**Re: Wal-Mart at 10224 North Coors, Administrative Amendment Request, Project #PR-2021-005077**

Please find responses below in bold addressing the Transportation Development Comments received February 18, 2021.

SHEET: CS1

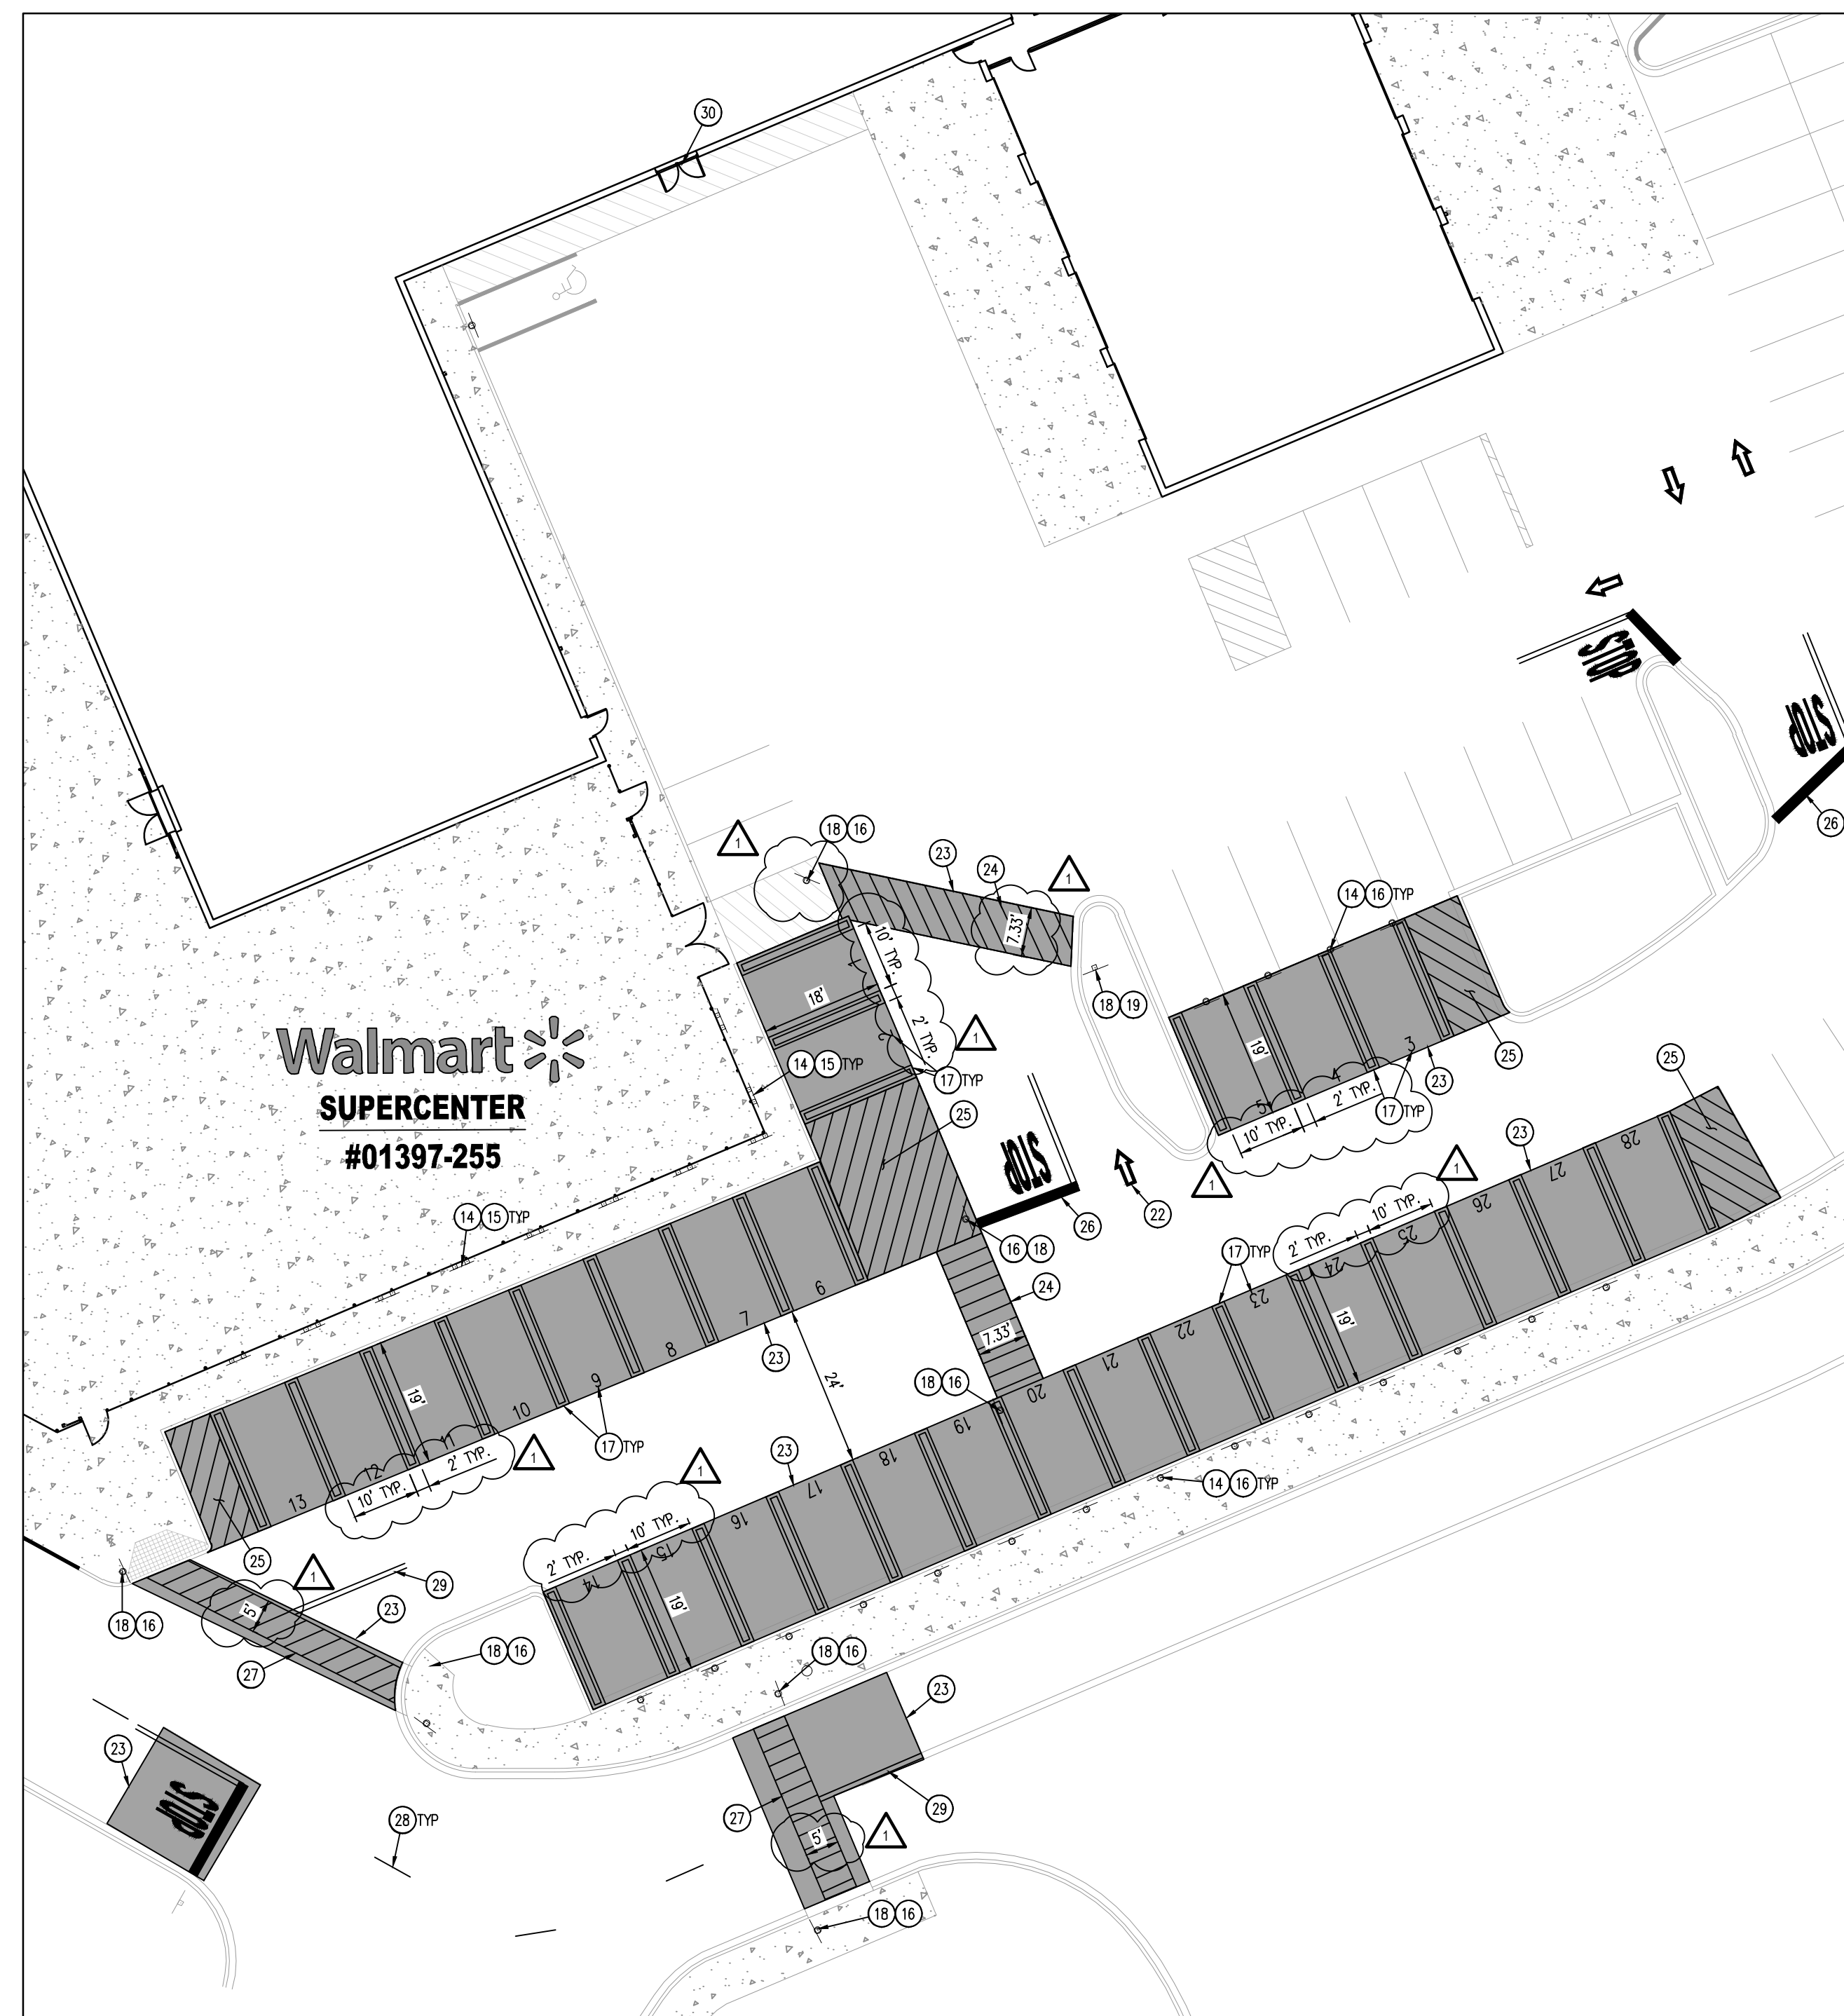
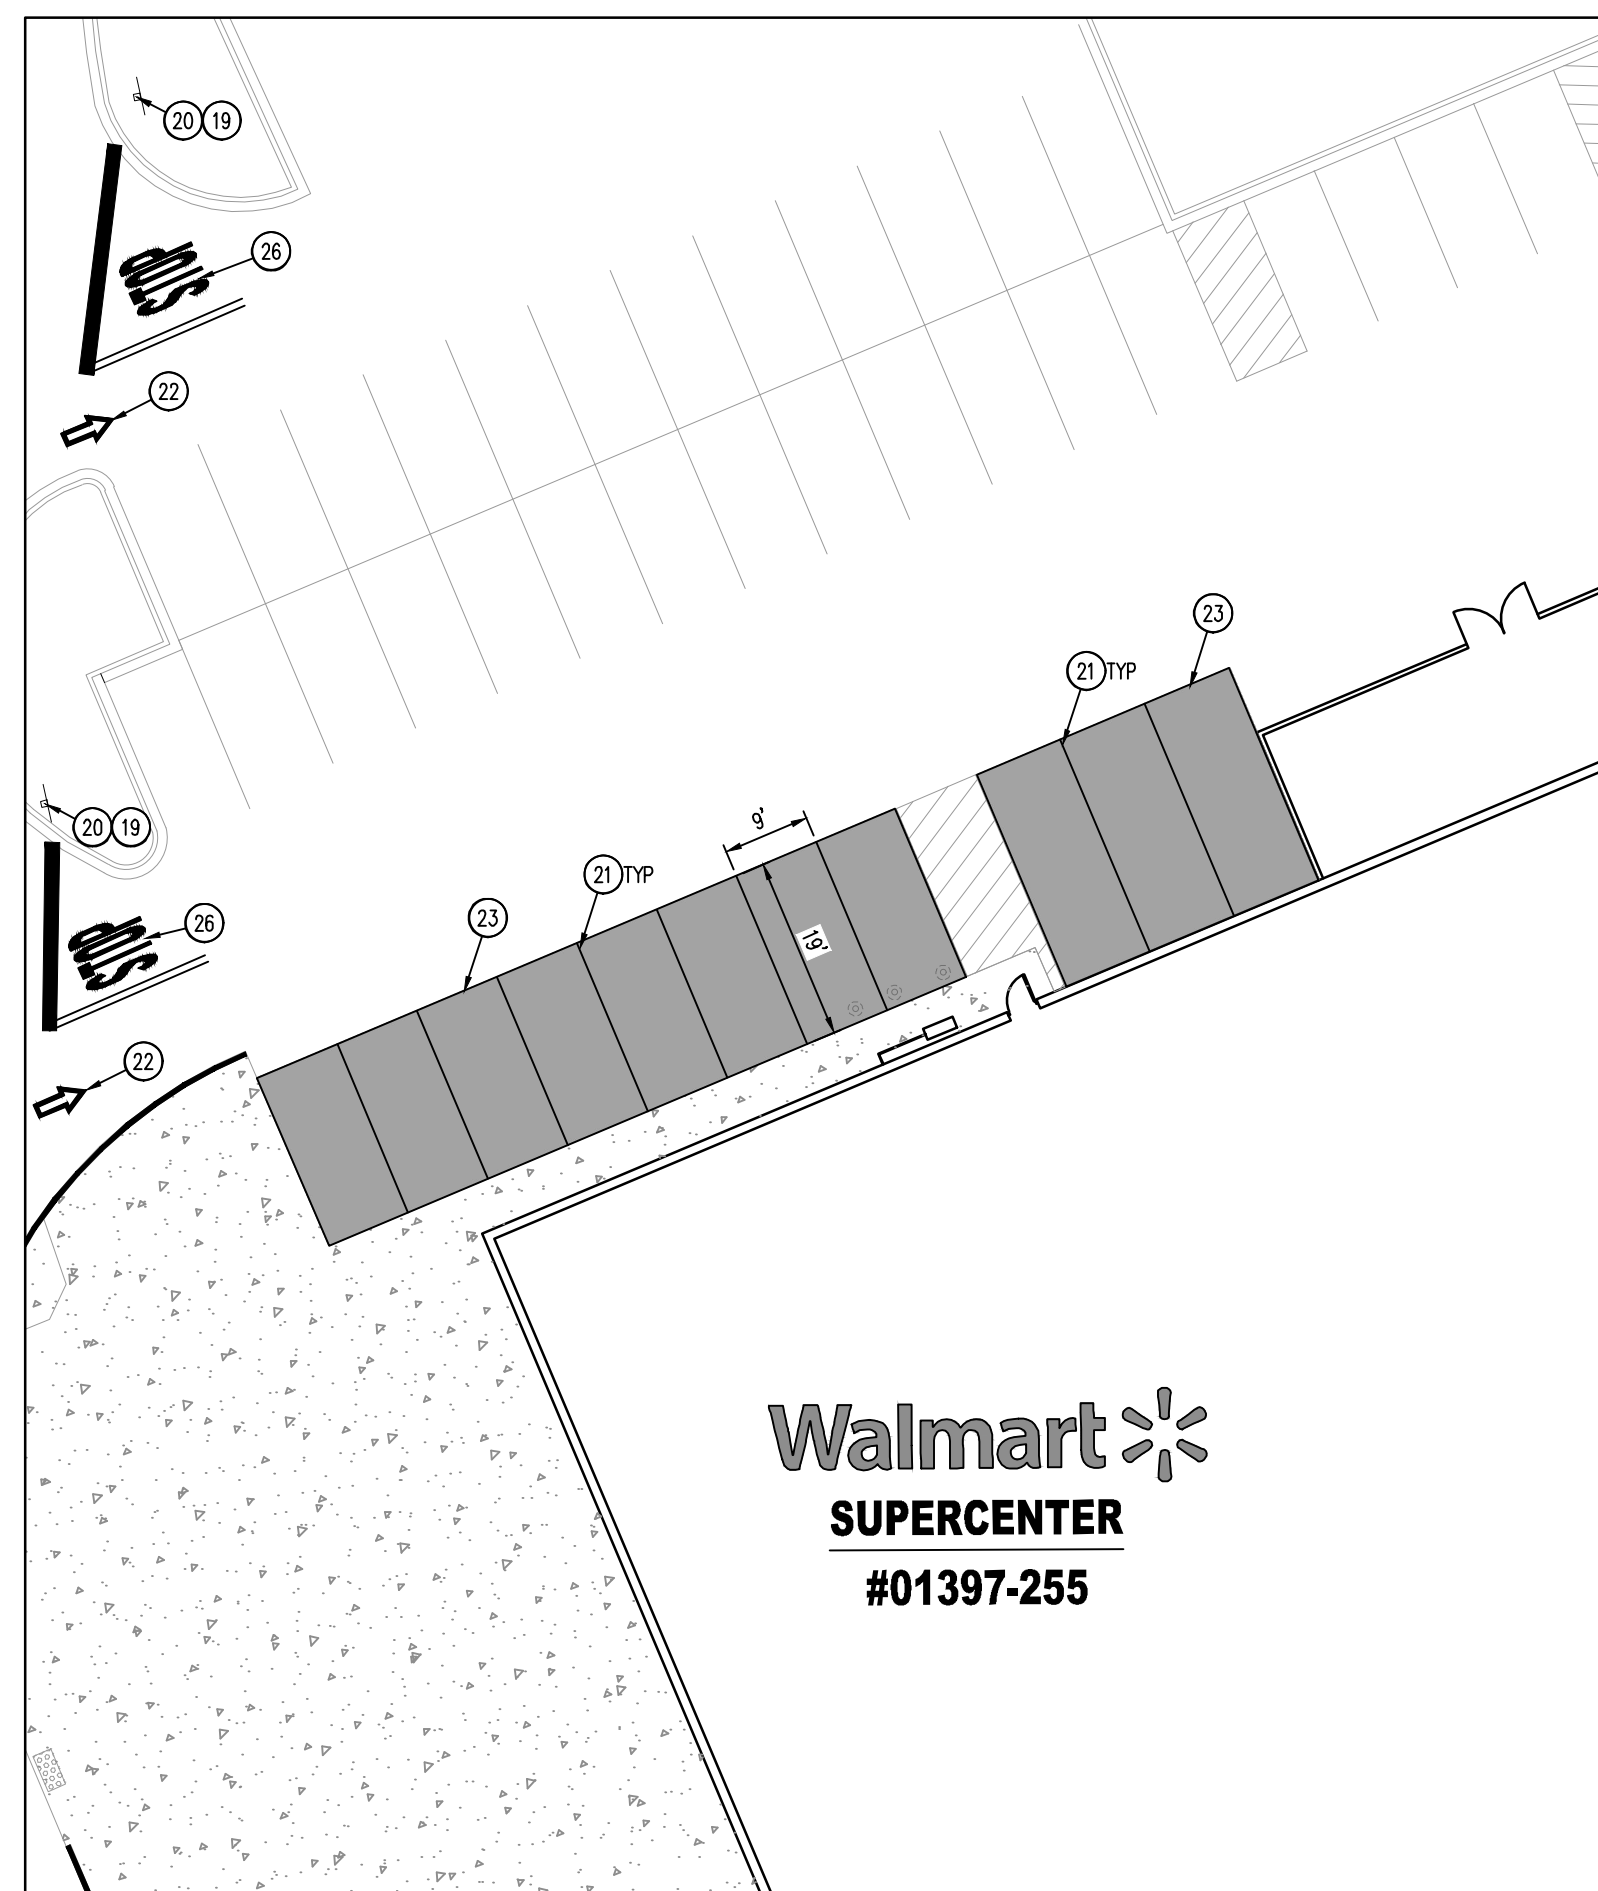
2. Dimension parking stalls and crosswalks between stalls on overall plan for pick-up parking spaces. Show pick-up signs at stalls on plan view with a keyed note. "Typical" notes can be used.

**Response: Crosswalk and parking stall dimensions added to Demolition & Site Plan Sheet CS1. Pick-up signs shown with keynote 14. Dimensions and signage keynotes utilize "Typical" as requested. It should be noted that plan sheet SECP-2, which shows the Pickup area, references CS1 for all Pickup detail including signage, dimensions, etc.**

3. Be sure to cross out keyed notes that are not used for this submittal. For signage details provided, delete any signage that is not used.

**Response: Unused key notes crossed out as requested. Detail standards are at Walmart's request for all projects to ensure consistency throughout all Walmart locations and have been left for consistency purposes. Please let us know if this is still of concern.**
